**BOCA®**  
**NATIONAL BUILDING CODE/1999**  
**PLAN REVIEW RECORD**

Valuation: To Be Determined Plan Review # 040331  
 Date: 04/15/04

BUILDING LOCATION 85 CENTRAL AVE PEASSE DS.  
 (Street address)

BUILDING DESCRIPTION 12388 SQ. FT. 12-RESIDENTIAL UNITS + ATTACH. BUILDING - WOOD FRAME.

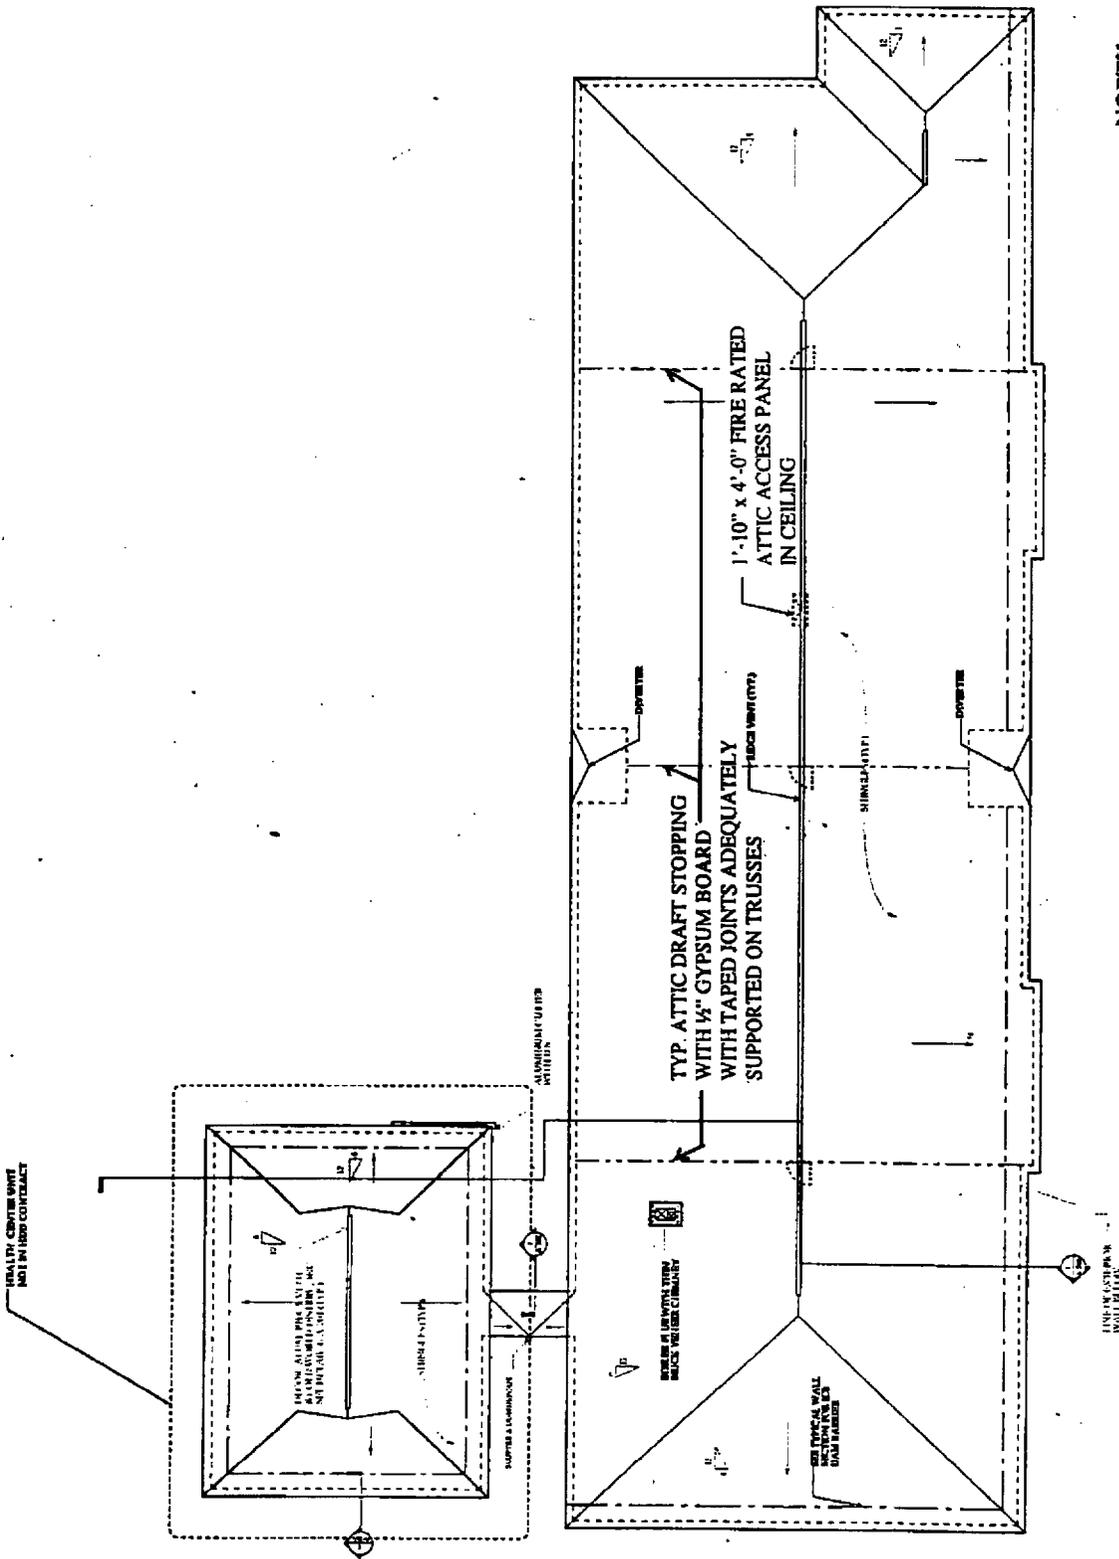
Fireblocking/draftstopping (721.0)  NEED

1 Section @ Typ. Exterior Wall
1/2" = 1'-0"

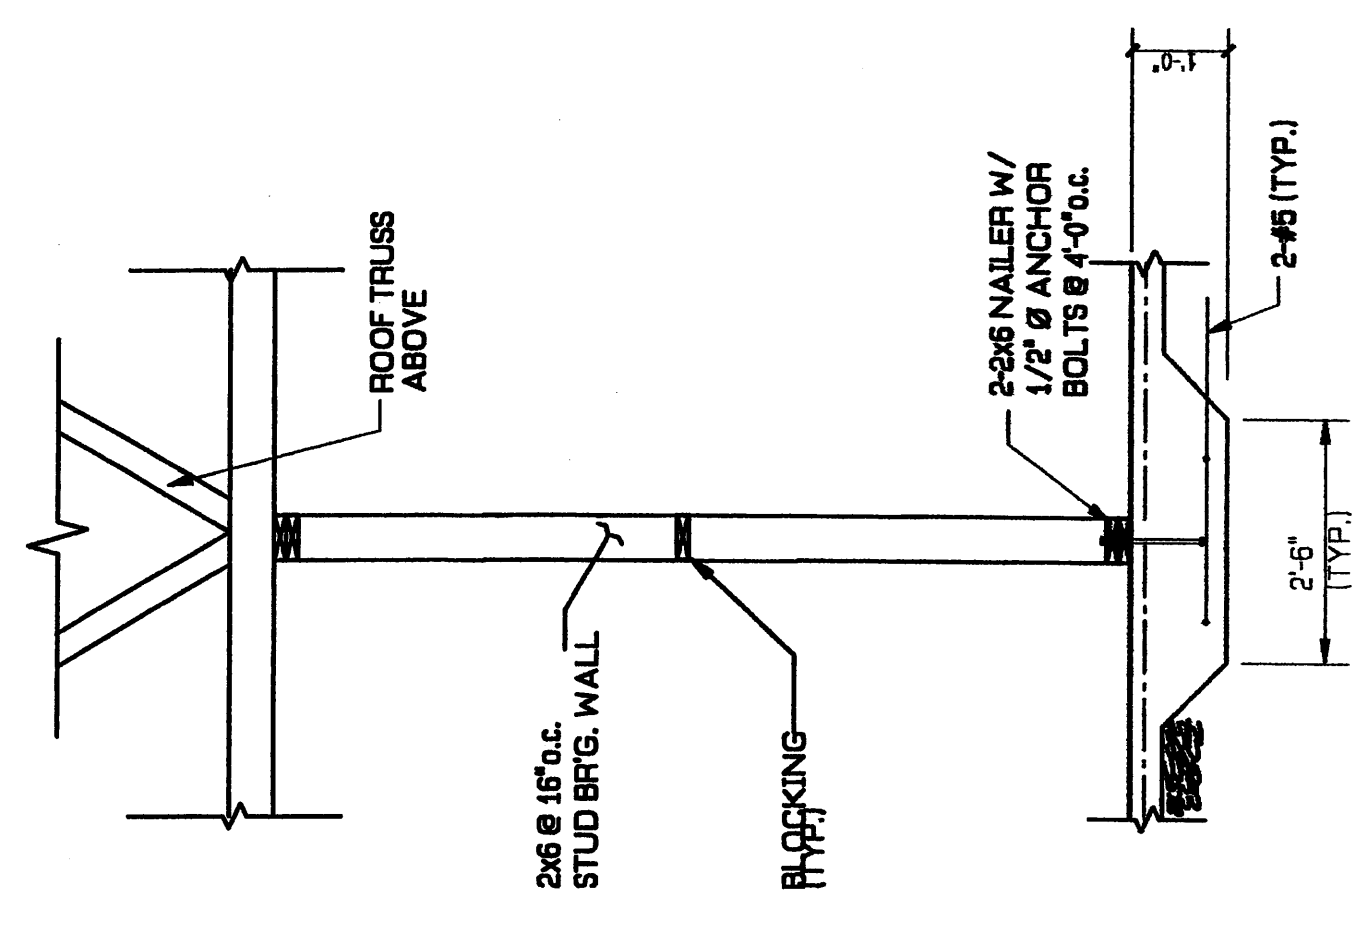
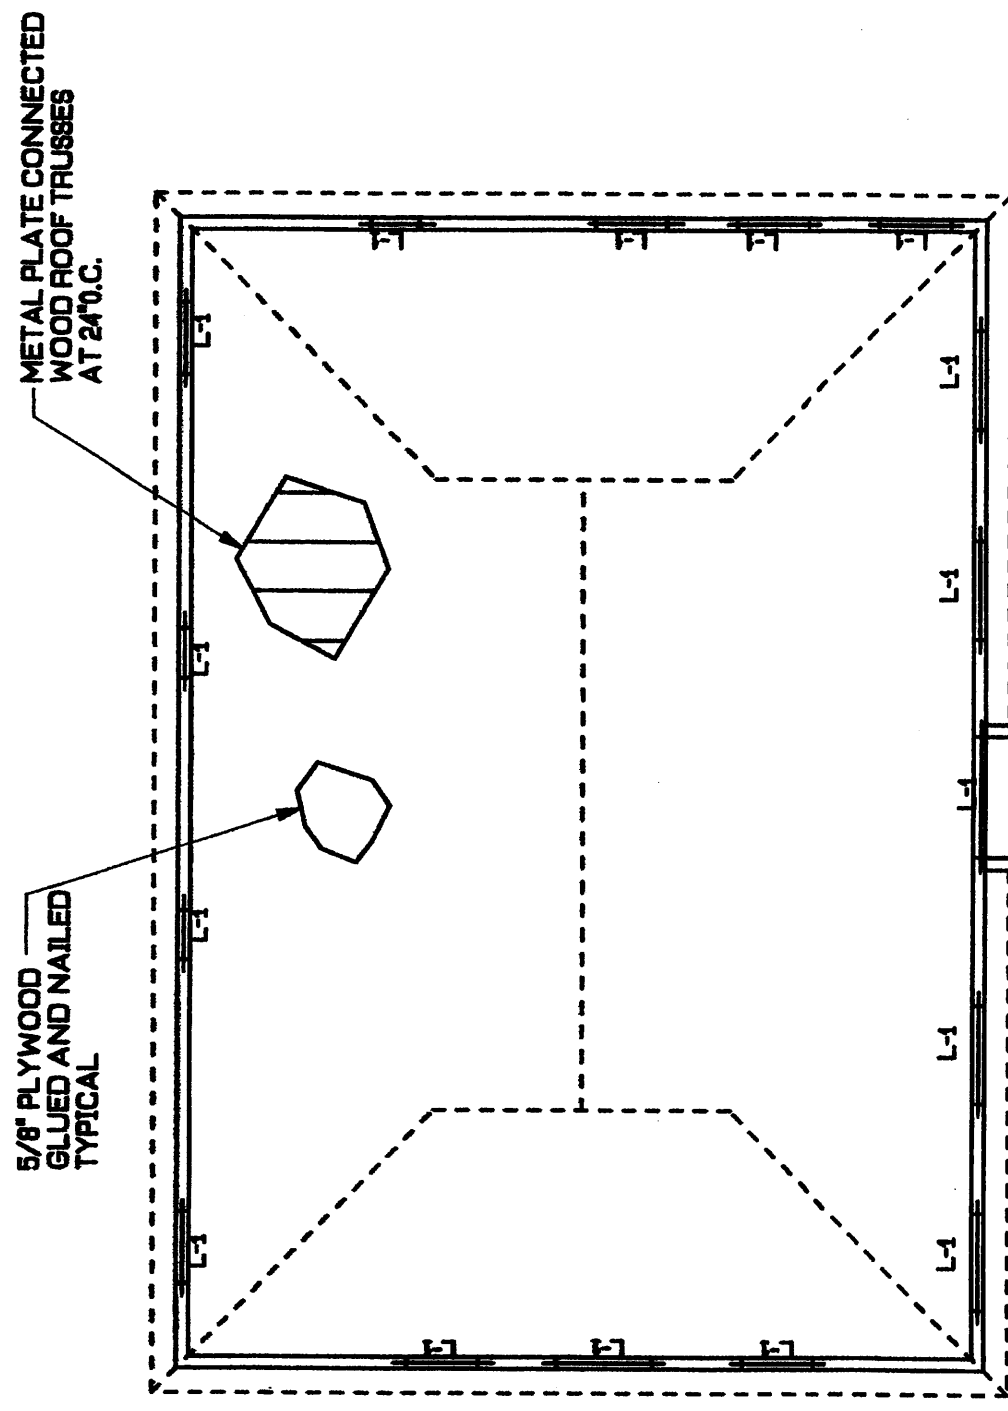
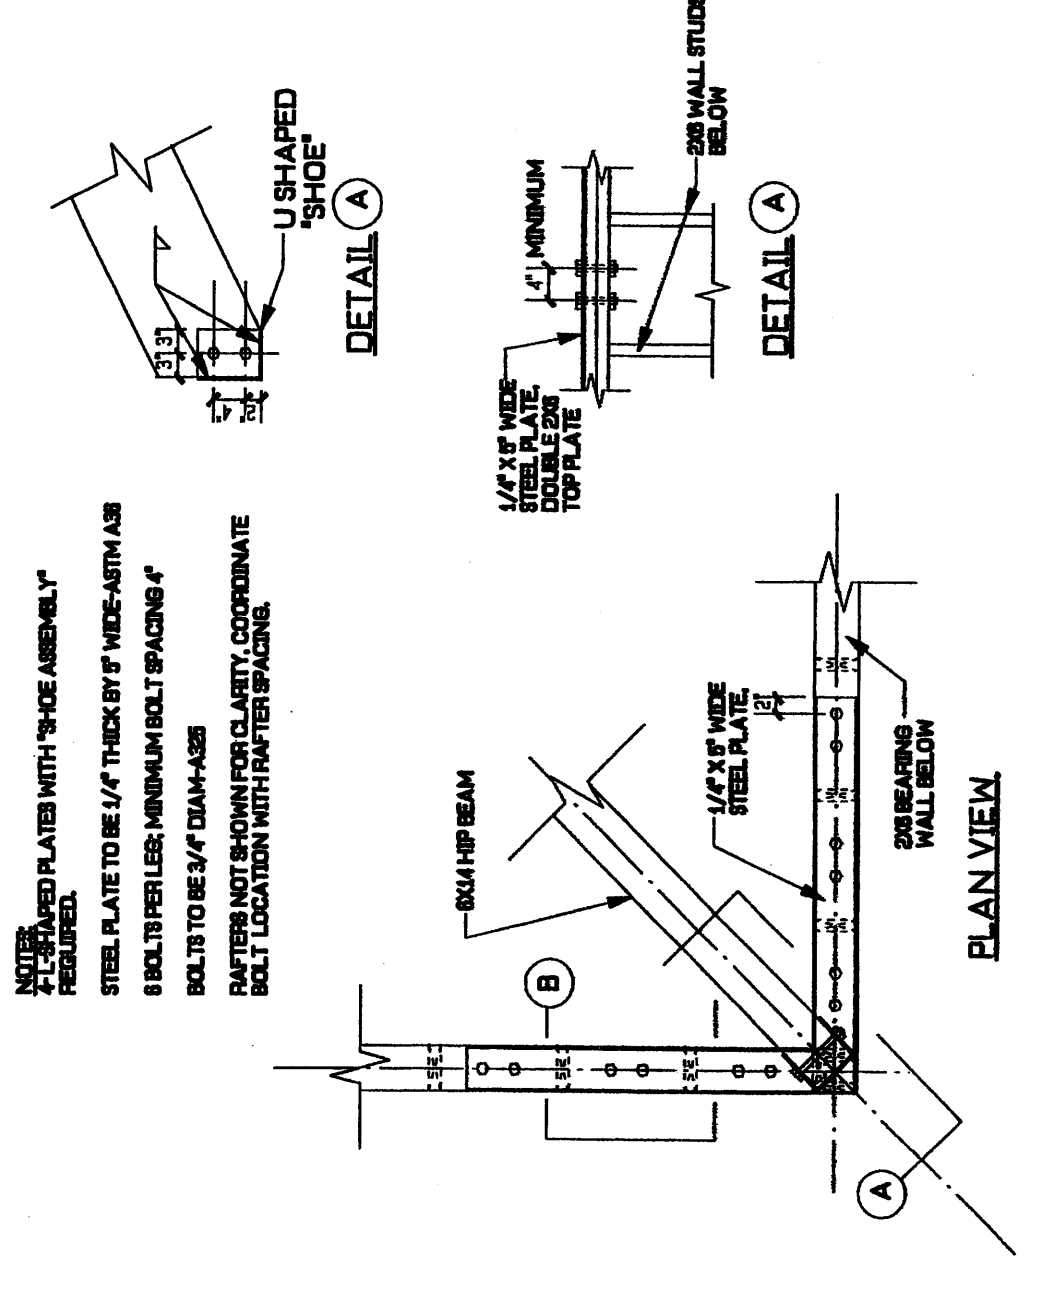
No.	DESCRIPTION
1	NEED GEOTECHNICAL REPORT (1804)
2	USE GROUPS - MIXED USE? SEPARATED OR NON SEPARATED?
3	ON PAGE 201-12 (1st BEARING WALL) FIRE SOUND RATING? (WALL & PARTIAL) (201-12) APARTMENT DOORS TO 117
4	CLIMBER ROOM AN OFFICE WINDOWS RATED
